**WEST SUSSEX COUNTY COUNCIL
STRATEGIC PLANNING CONSULTATION**

SUBJECT: BE/98/12/PO - App to modify Planning Obligation dated 04/08/2006 under BE/45/04 & subsequent Deed of Variation dated 10/03/2010 in respect of flood compensation area, healthcare, open space, sports facilities and highway upgrade contribution.

Site 6, Land North of Bersted, Chichester Road, Bersted, Bognor Regis, West Sussex

1. ALL DIMENSIONS ARE IN METRES UNLESS STATED OTHERWISE.
2. THE DRAWING SHOULD BE READ IN CONNECTION WITH ALL OTHER RELEVANT ARCHITECT & ENGINEERING DETAILS, DRAWINGS & SPECIFICATIONS.

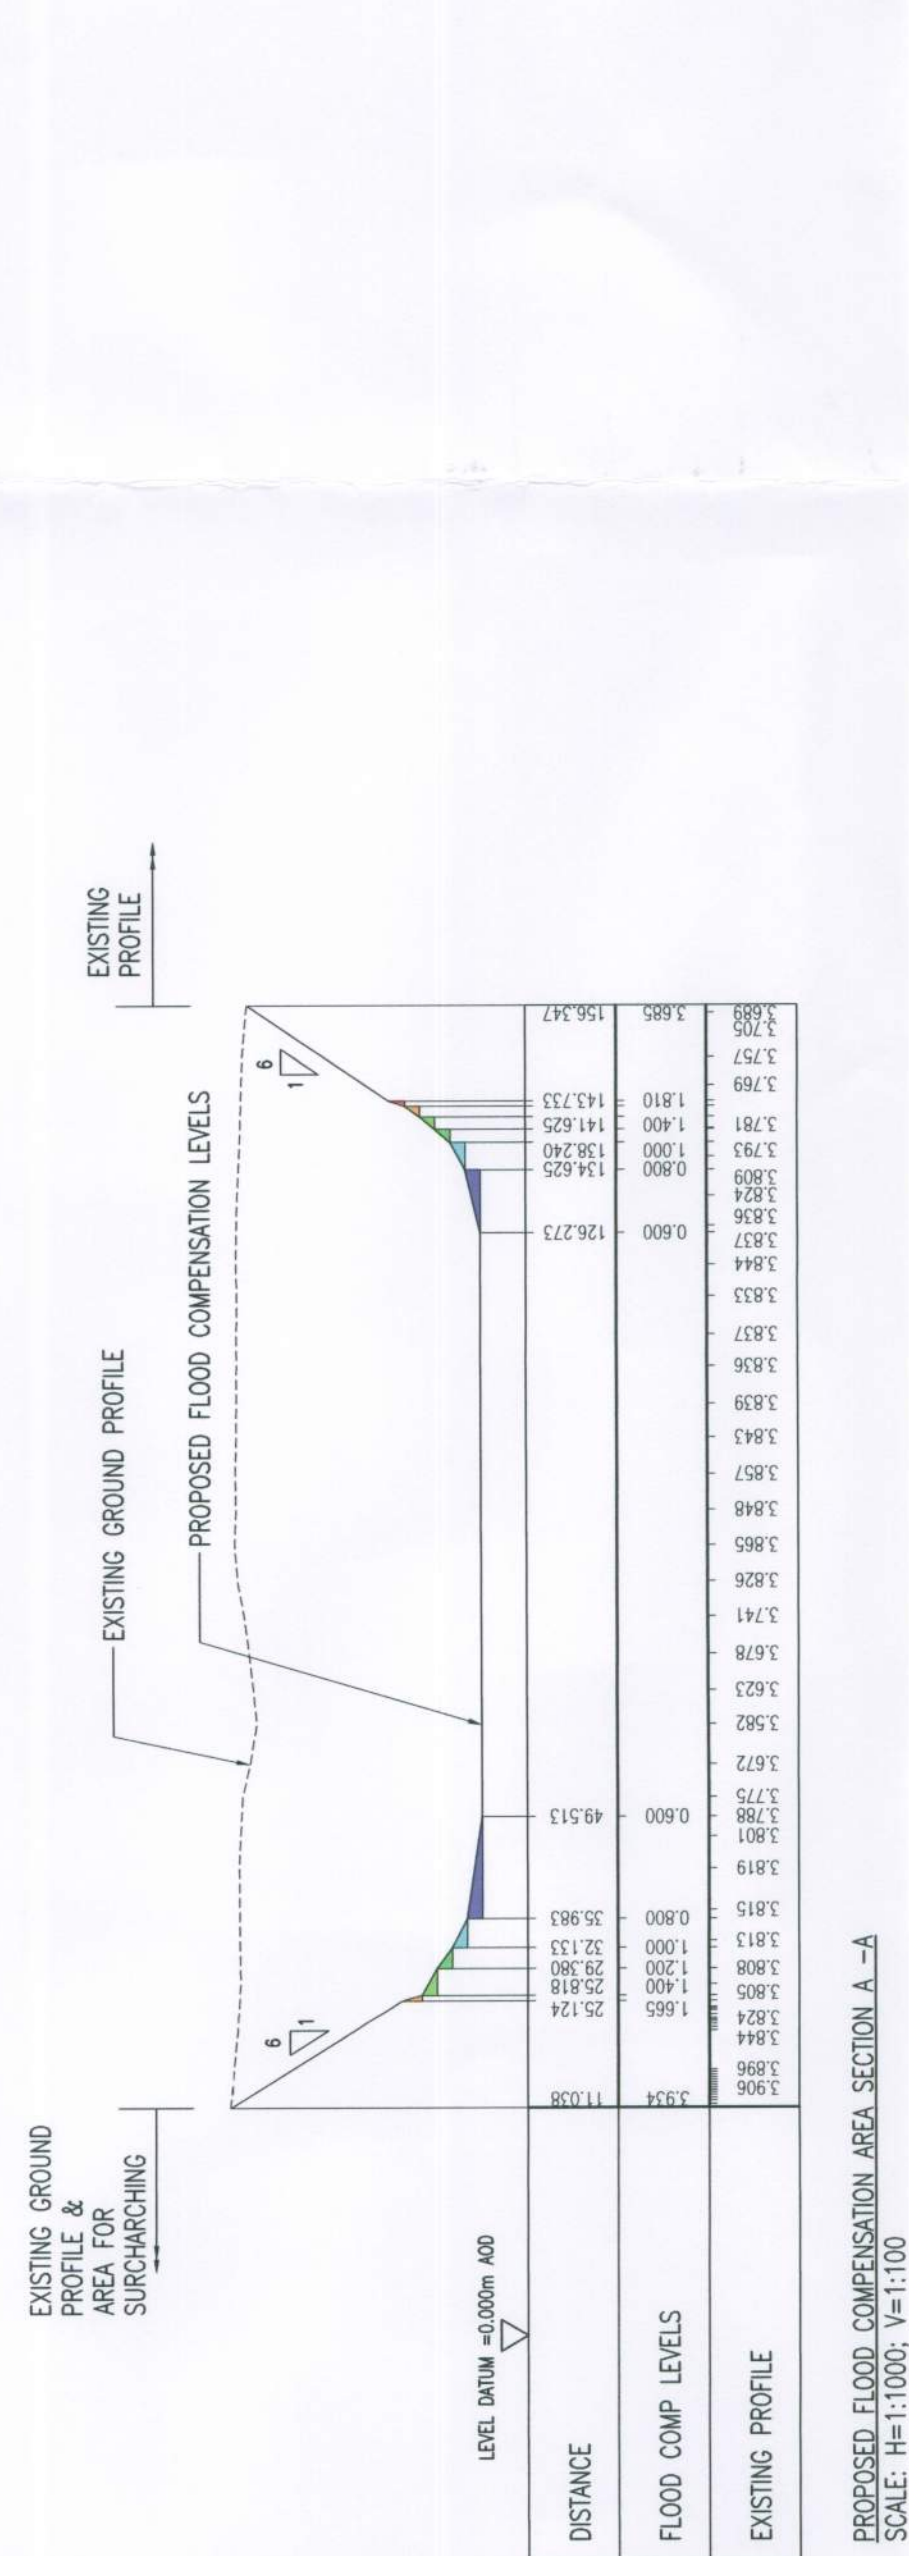
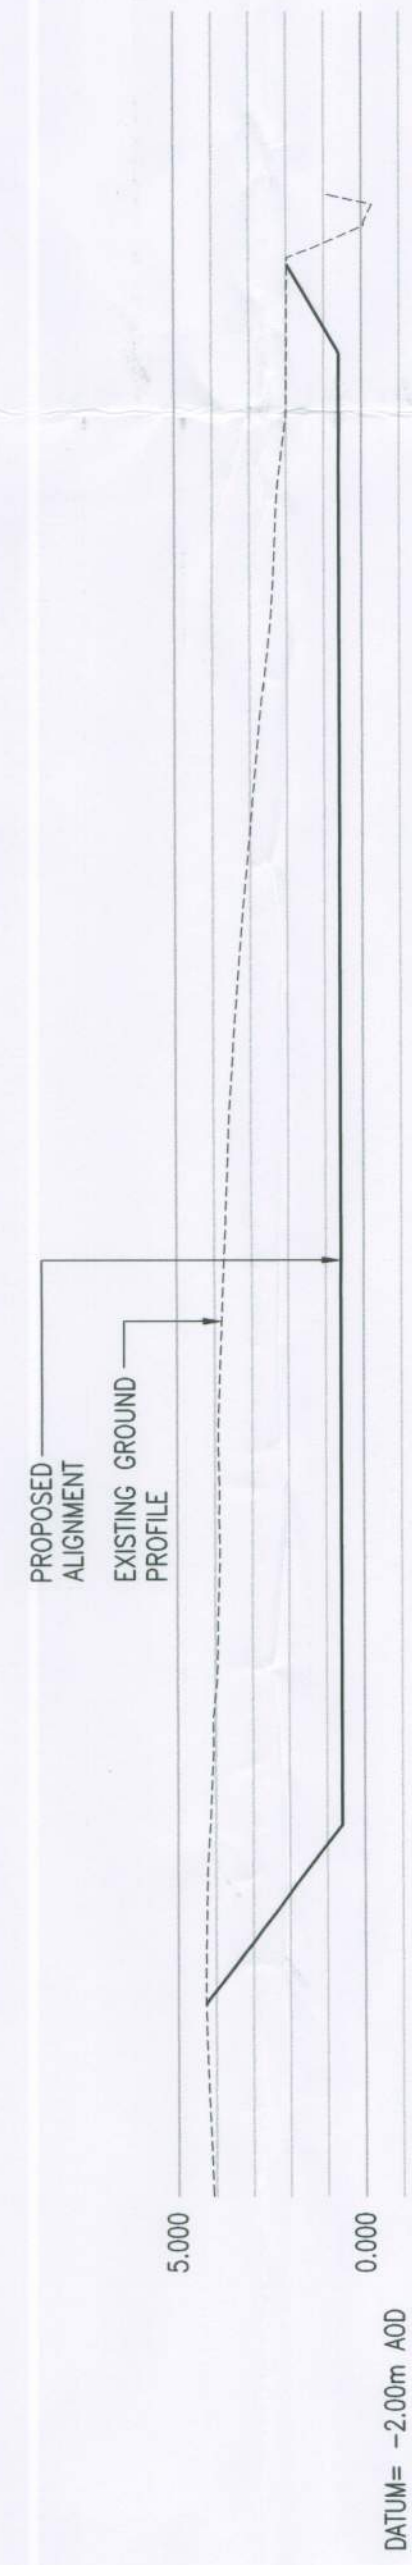
Flood Compensation Area - Revised trigger proposed for the construction of the FCA increased to 350 dwellings. This is acceptable technically, providing the FCA is completed before the road is completed and the Environment Agency have no objections.
